Application for a non-material amendment following a grant of planning permission.
 Town and Country Planning Act 1990

Conversion of Agricultural Barn into Dwelling House

PF/17/0068 + RV/23/1005

Alterations to Frankfort Barn, Worstead. NR28 9RU

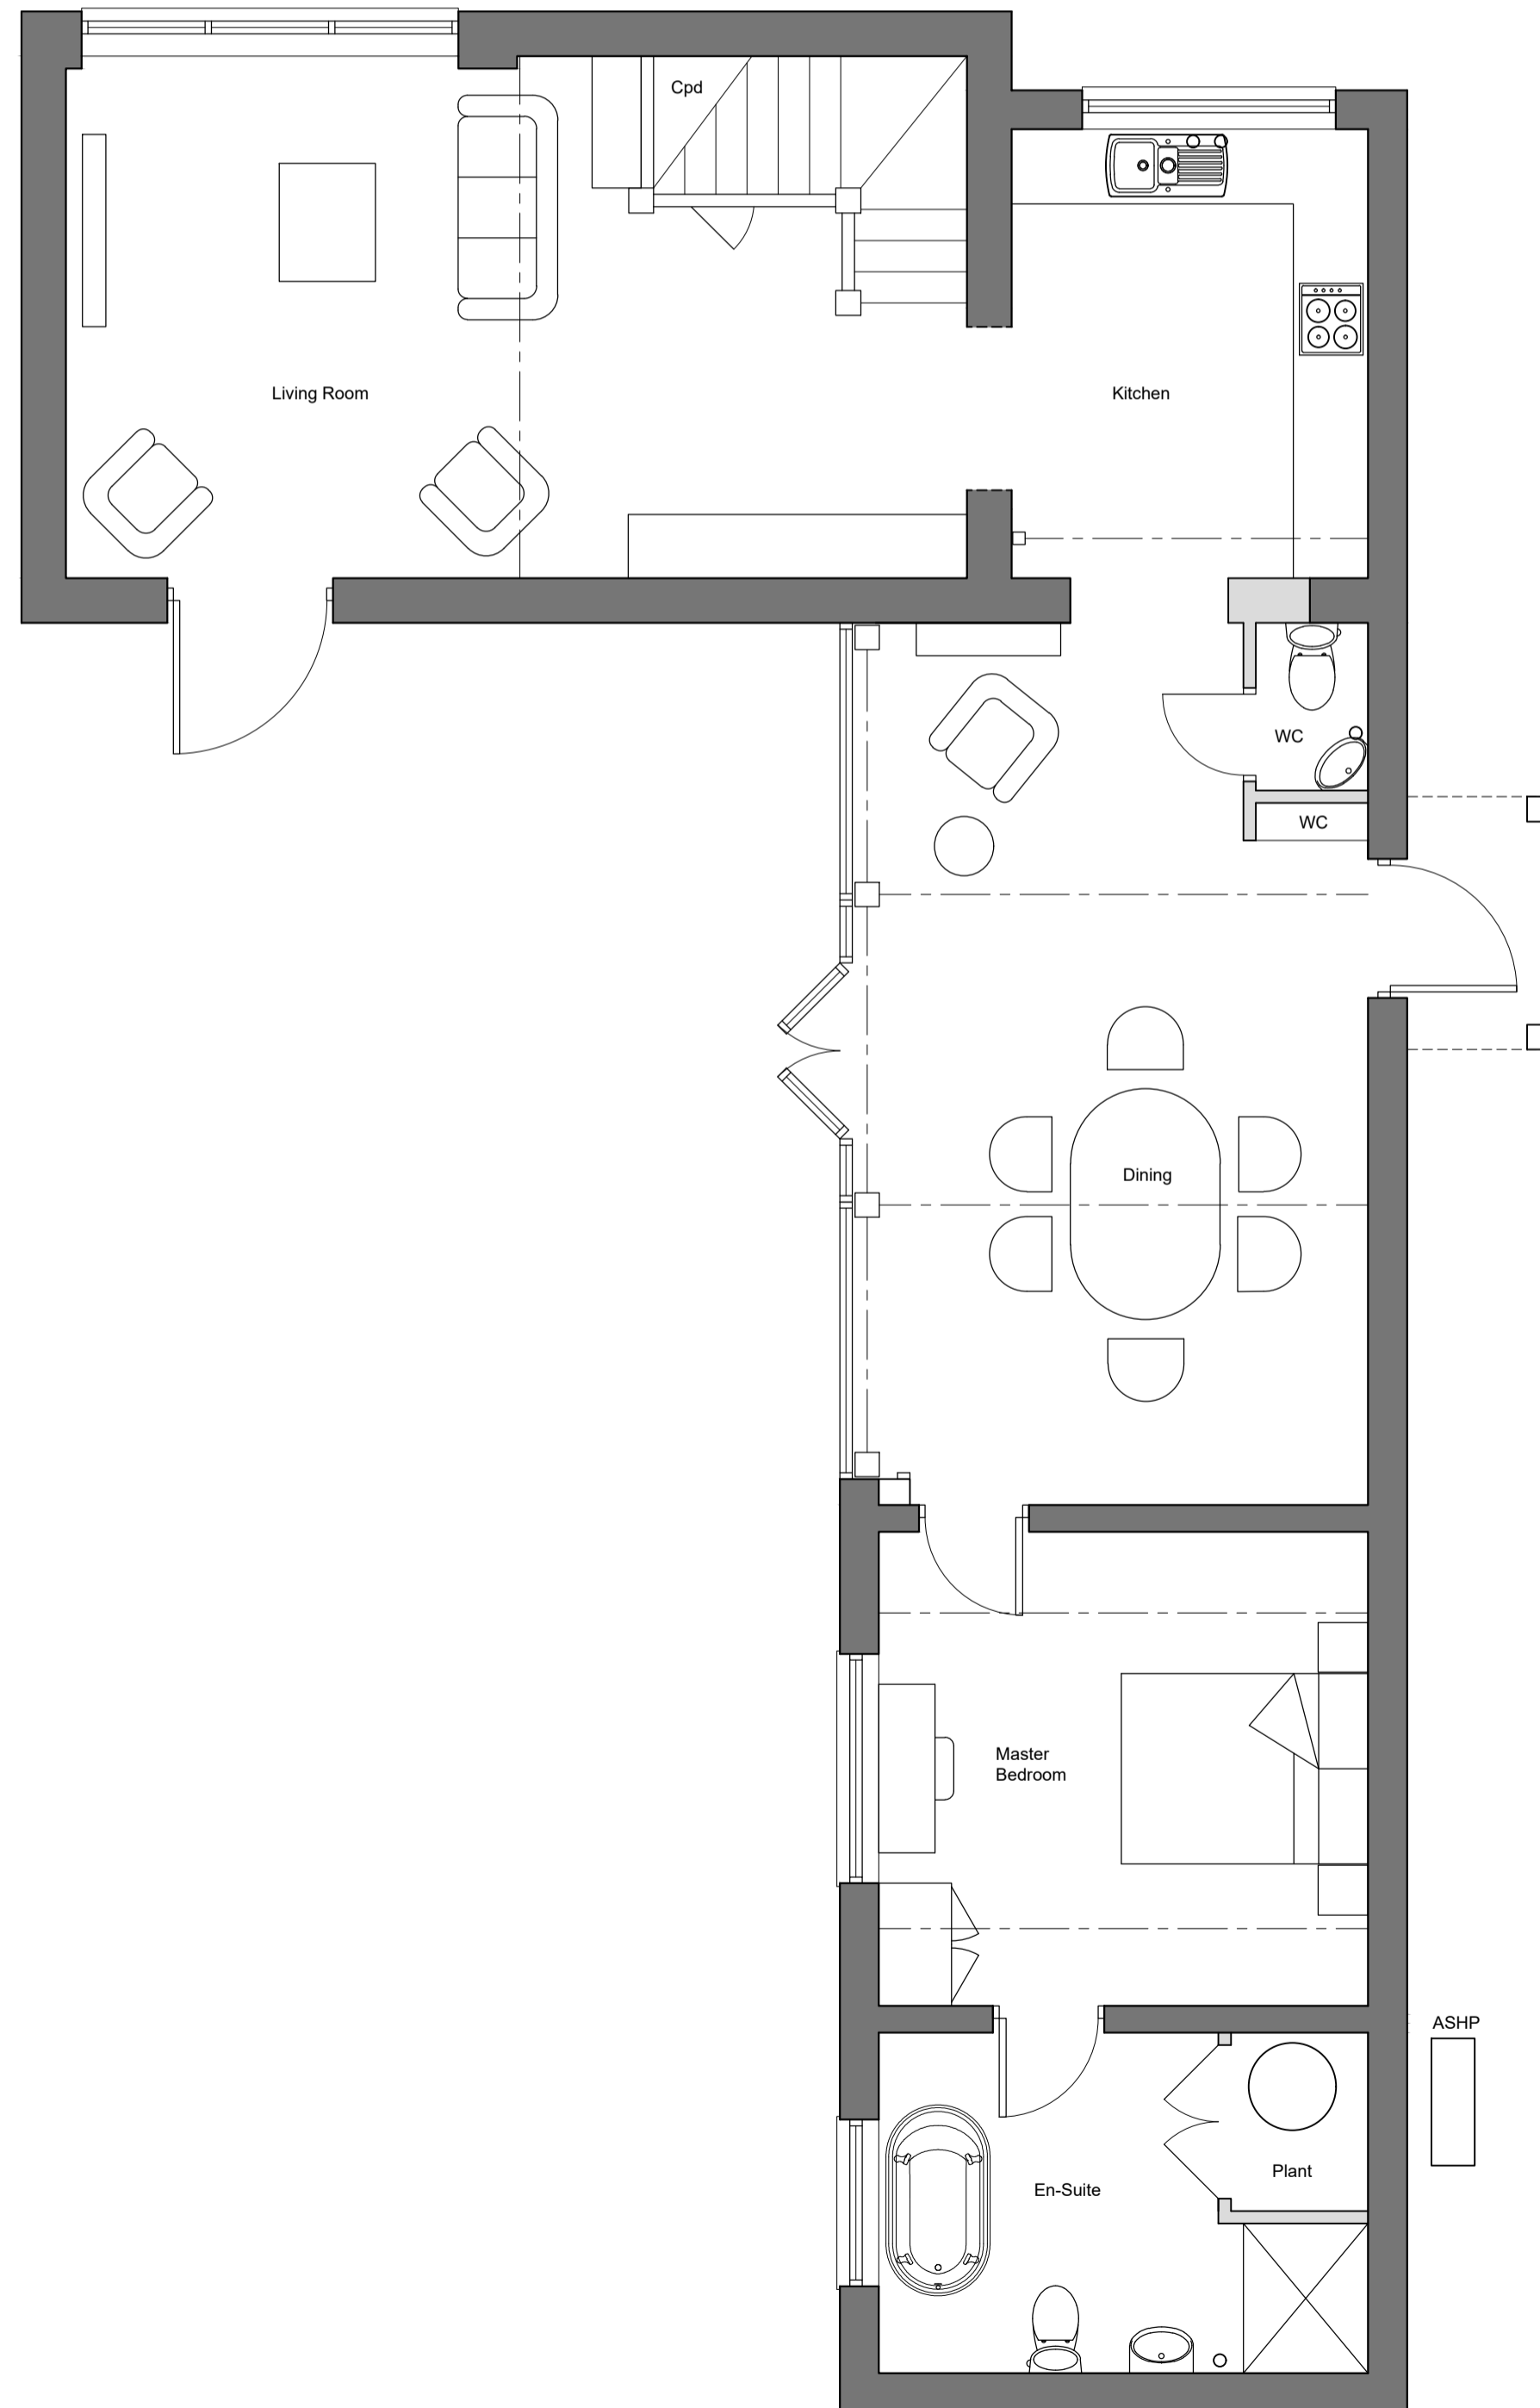
First Floor South Windows to North Elevation.
Caddy South Window to West Elevation. New Window
in North Elevation. Redlight Removal from First
Floor Bathroom.
